15 November 2022

TfNSW Reference: SYD20/01234/06

DPIE Reference: SSD-10272349

## **RESPONSE TO SUBMISSIONS REVISED INFORMATION - YIRIBANA LOGISTICS ESTATE - KEMPS CREEK**

FUNCTIONAL LAYOUT PLAN
SCALE 1:250

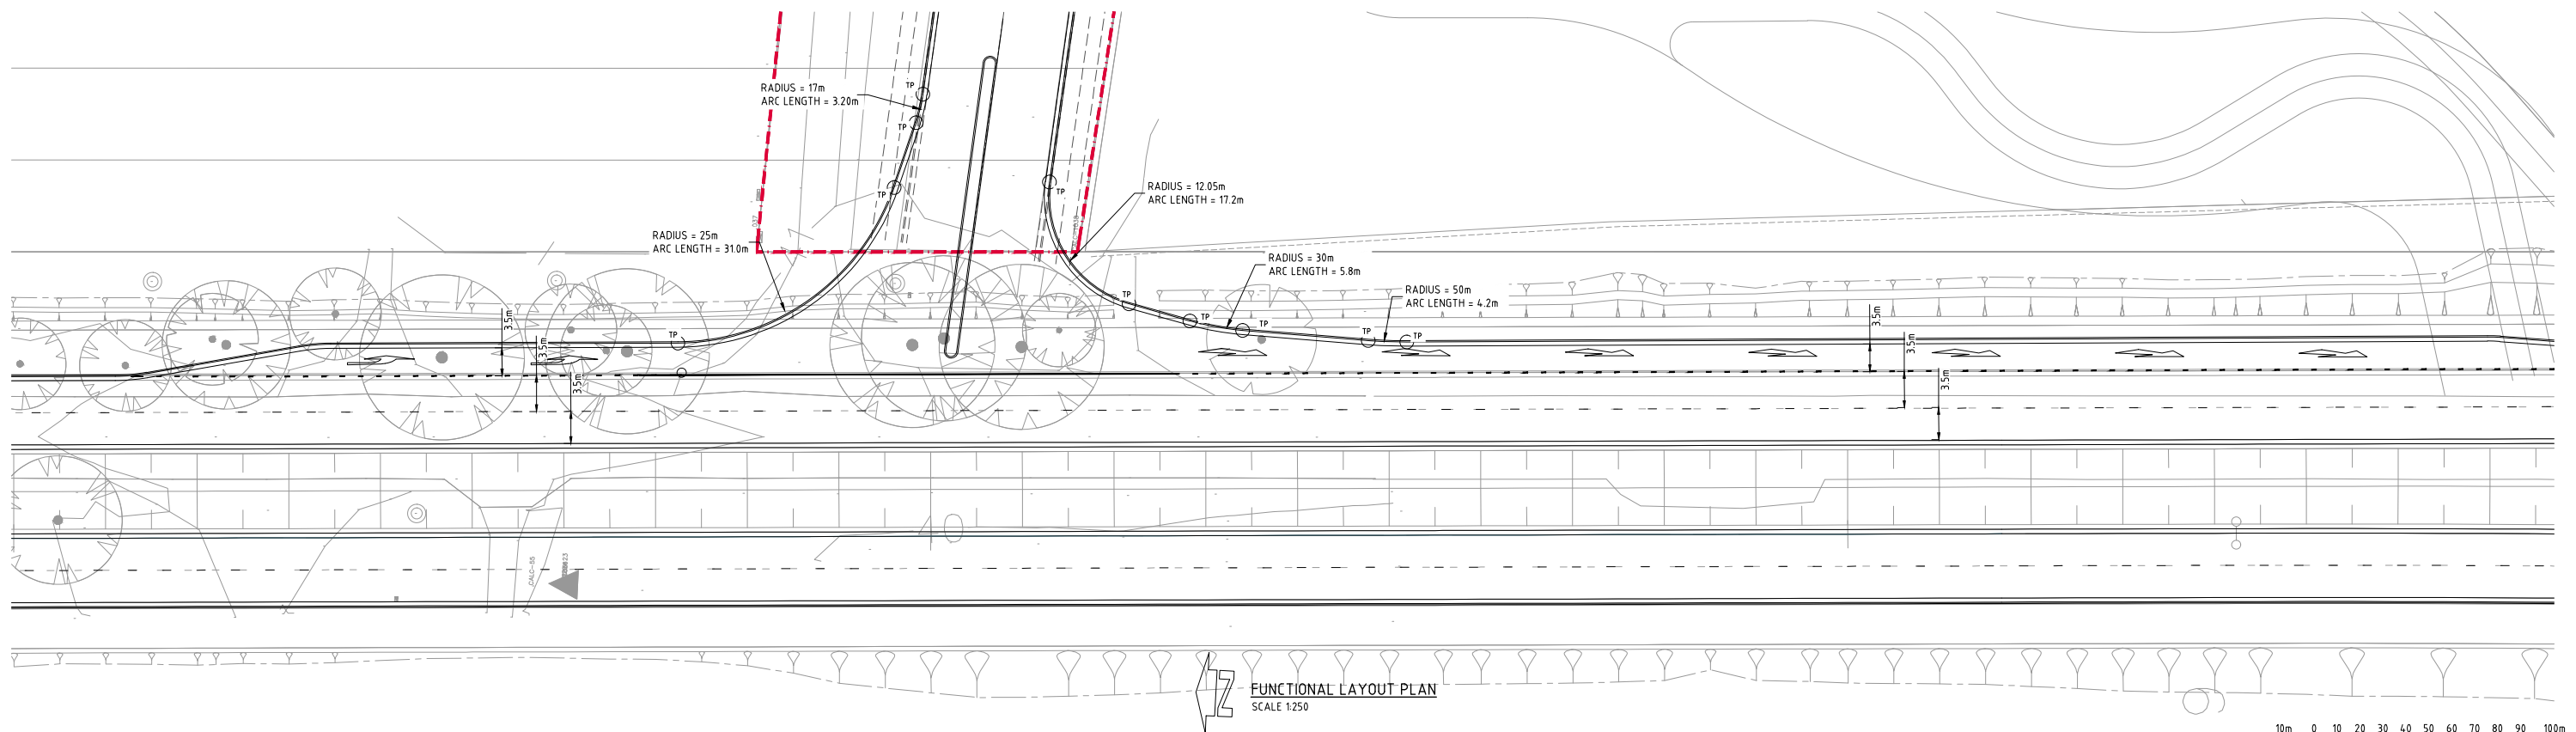
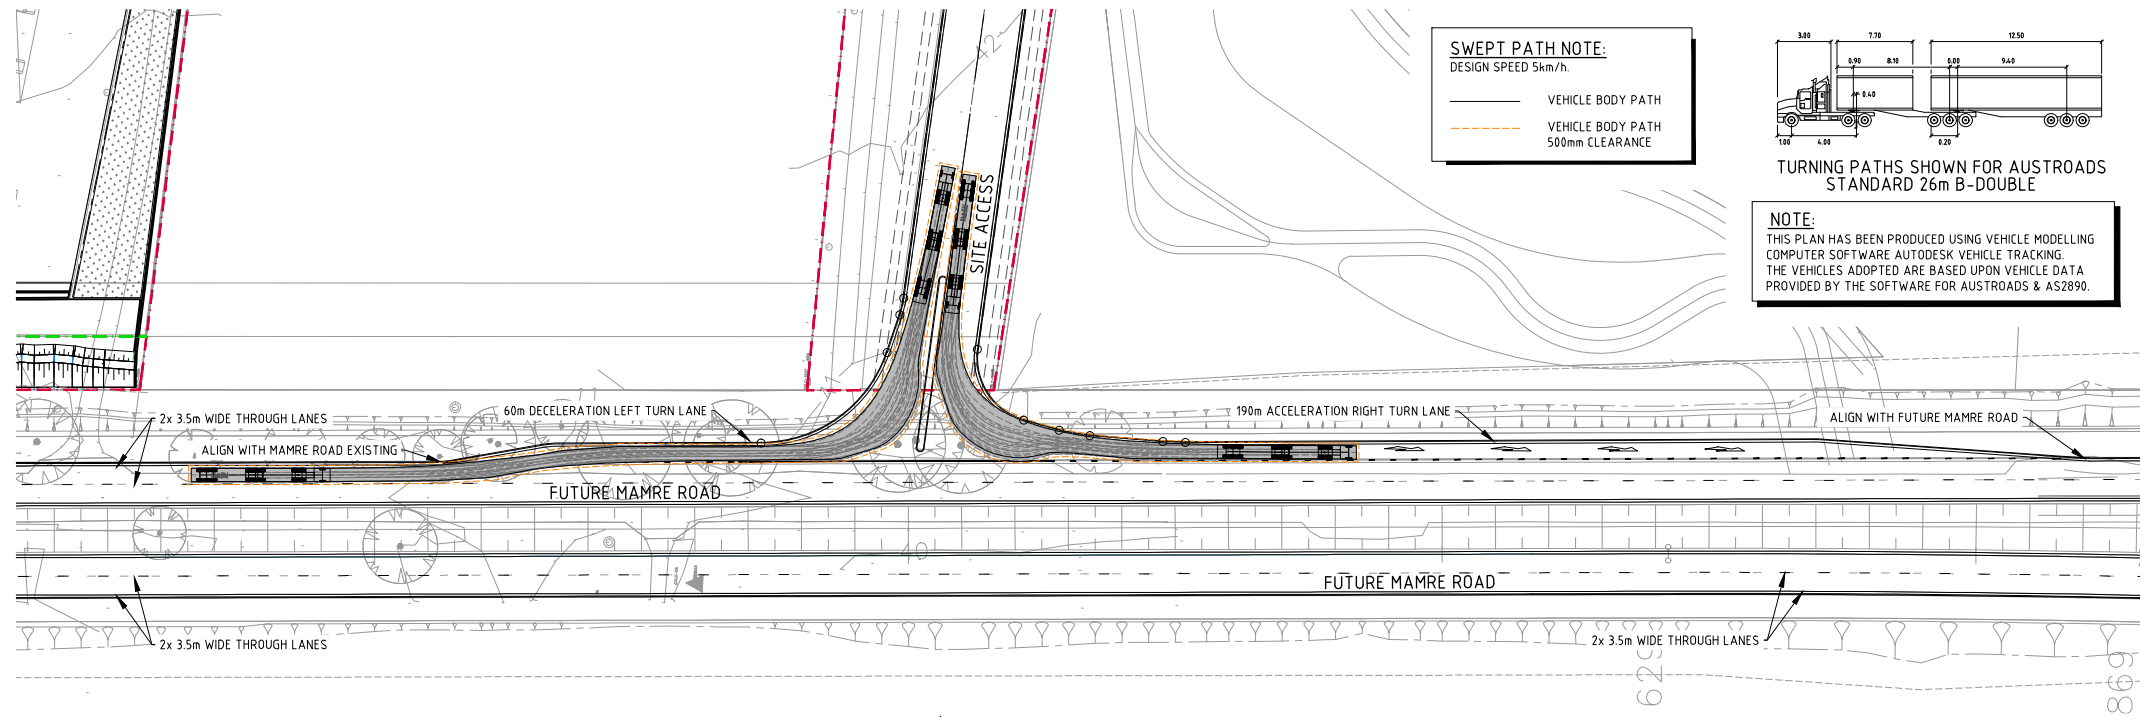
2. The intersection design and access arrangement (left in/left out), is dependent on a redundant traffic model which does not reflect the current or future development loadings for network use within Mamre Road. The acceleration lane proposed to service the site along Mamre Road requires land not linked to the current application to function. The Applicant is advised to amend the application to include all allotments relevant to the proposal or revise the access arrangement to reroute vehicular movement via the local industrial road.

Given the above matters TfNSW are unable to support the current access arrangement. TfNSW recommends that the applicant review the above in conjunction with the previous iterations of advice and revise the design according.
